From: Brian Holland
Sent: 05 September 2011 17:42
To: Planning.Responses
Subject: RE: Planning Consultation on: EG/33/11/
 Engineer's Response

APPLICATION NO: EG/33/11/

Registered: 20-JUN-11
Site Address: Greenoaks Barnham Road Barnham PO22 0EB

Description of Works: Proposed redevelopment of land to provide 13 no. new dwellings to include 4 no. 2 bed houses, 6 no. 3 bed houses, 1 no. 4 bed house & 2 no. 5 bed houses. Together with associated access, car parking, landscaping & retention of existing property

RBA 895 - 50 P8

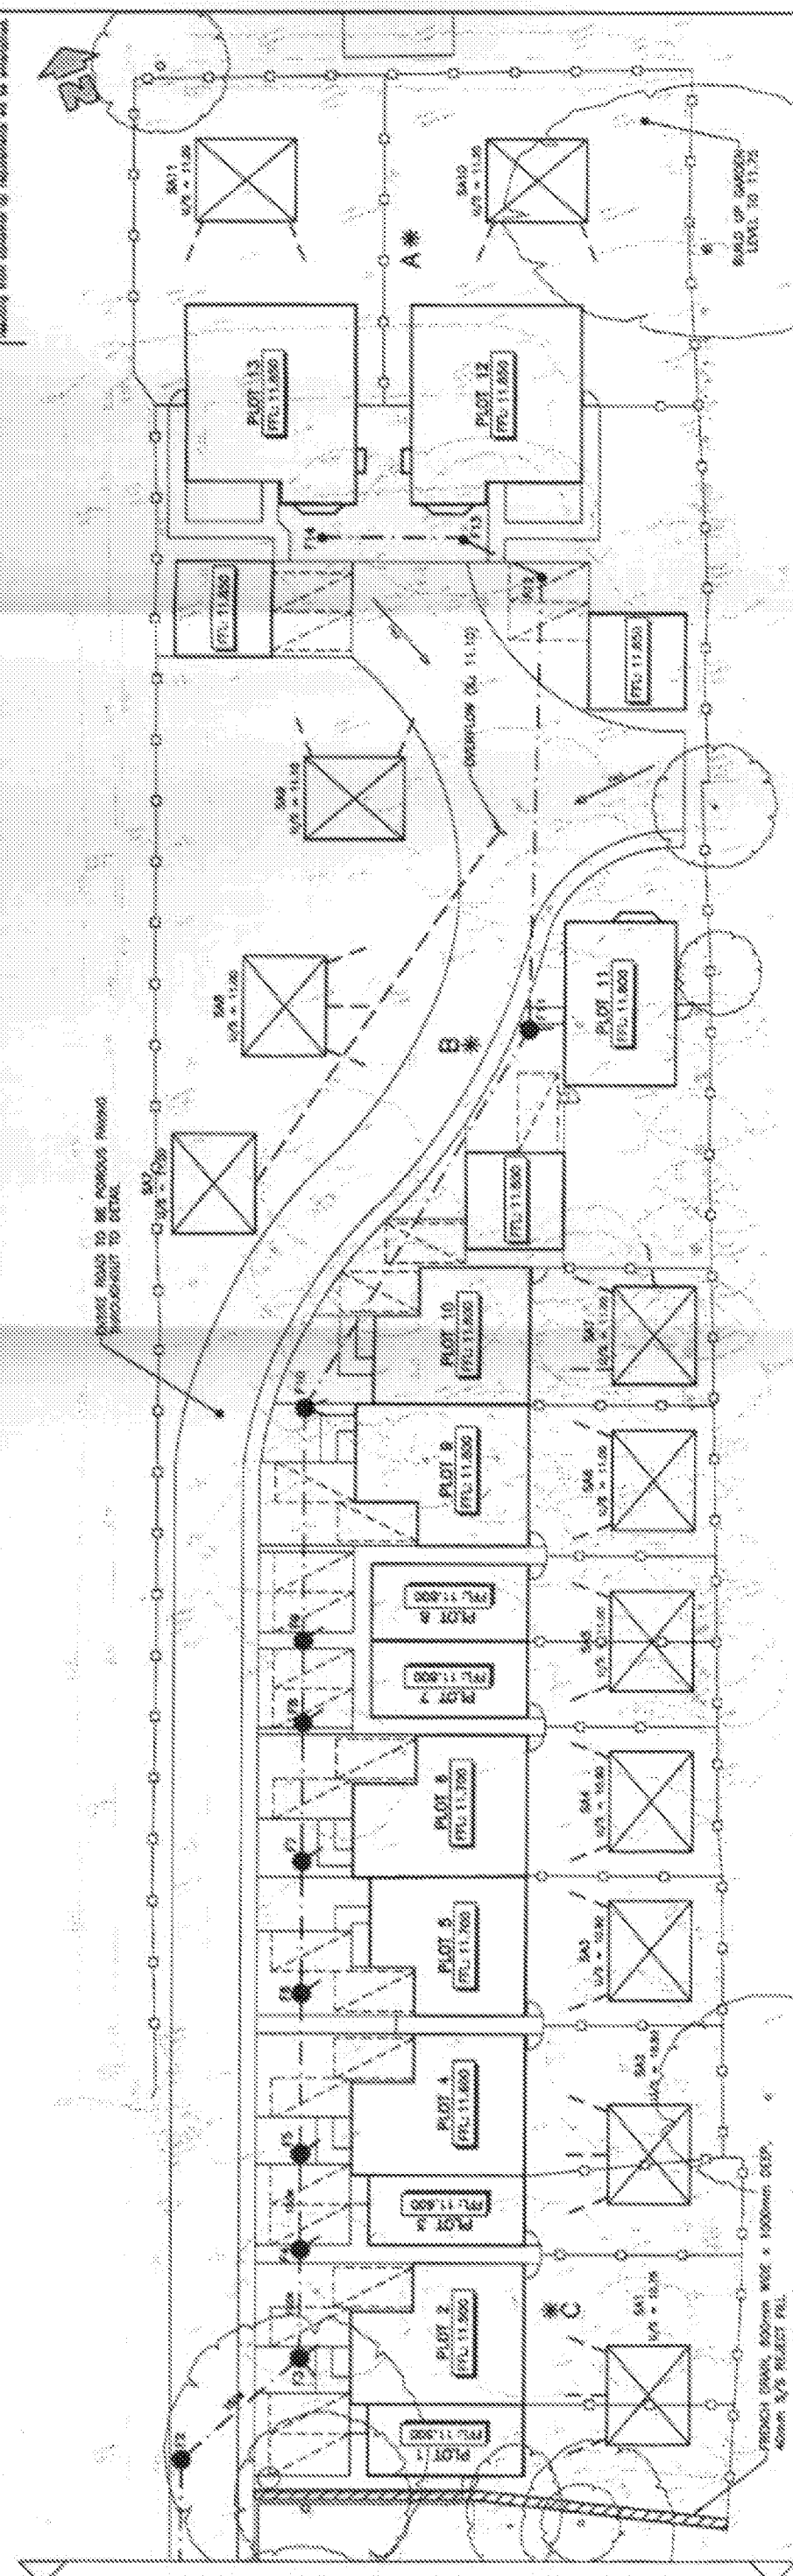
Some of the areas feeding into the individual soakaways appears to be in excess of the impermeable area of 75m² used in the design. It is also not clear from drawing no. RBA895/50 Rev P6 which areas drain into which soakaways, particularly at the northern end of the site. In the variable circumstances that exist on this site, designs should be submitted for each individual soakaway and also permeable pavement/driveway areas. It is possible that any excess water at the southern end of the main driveway would flow onto the existing public highway rather than into the overflow soakaway proposed at the higher end of the new road. The permeable pavement may require construction in self contained zones to ensure utilisation of all storage capacity due to the longitudinal gradient of the road. The use of 100% void ratio for the design of the soakaways is also a concern, details of the construction would be required to confirm this.

Also, due to the proximity of the top of the rectangular pit soakaways to the ground level, the garden area in which the soakaways are sited would need to be permanently devoid of any planting and designated as a 'no dig zone' to avoid damage to the soakaway structure and possible reduction in future storage capacity. They would probably require covering with a permeable geotextile to ensure no infiltration of debris. Details of the proposed method of erecting fencing within the soakaway areas are also required to enable consideration of the impact of this on the soakaways function.

Further details of the proposed method of surface water disposal are therefore required for our consideration.

SOAKAWAY DESIGN - BRE DIGEST 365

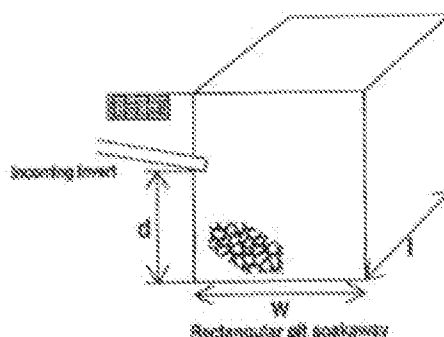
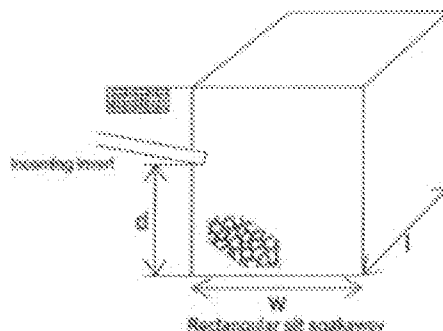
There are not adequate details of the soakaway designs provided. It is apparent that the top of the soakaways must be near or at ground level. It will therefore be necessary to take into account the rainfall that also lands on the area of the soakaway itself as this will also be contributing to the input flow into the soakaway. The area of the surface of the soakaway should therefore be added to the impermeable area that is being fed into the soakaway to give a total area for which the soakaway needs to be designed.
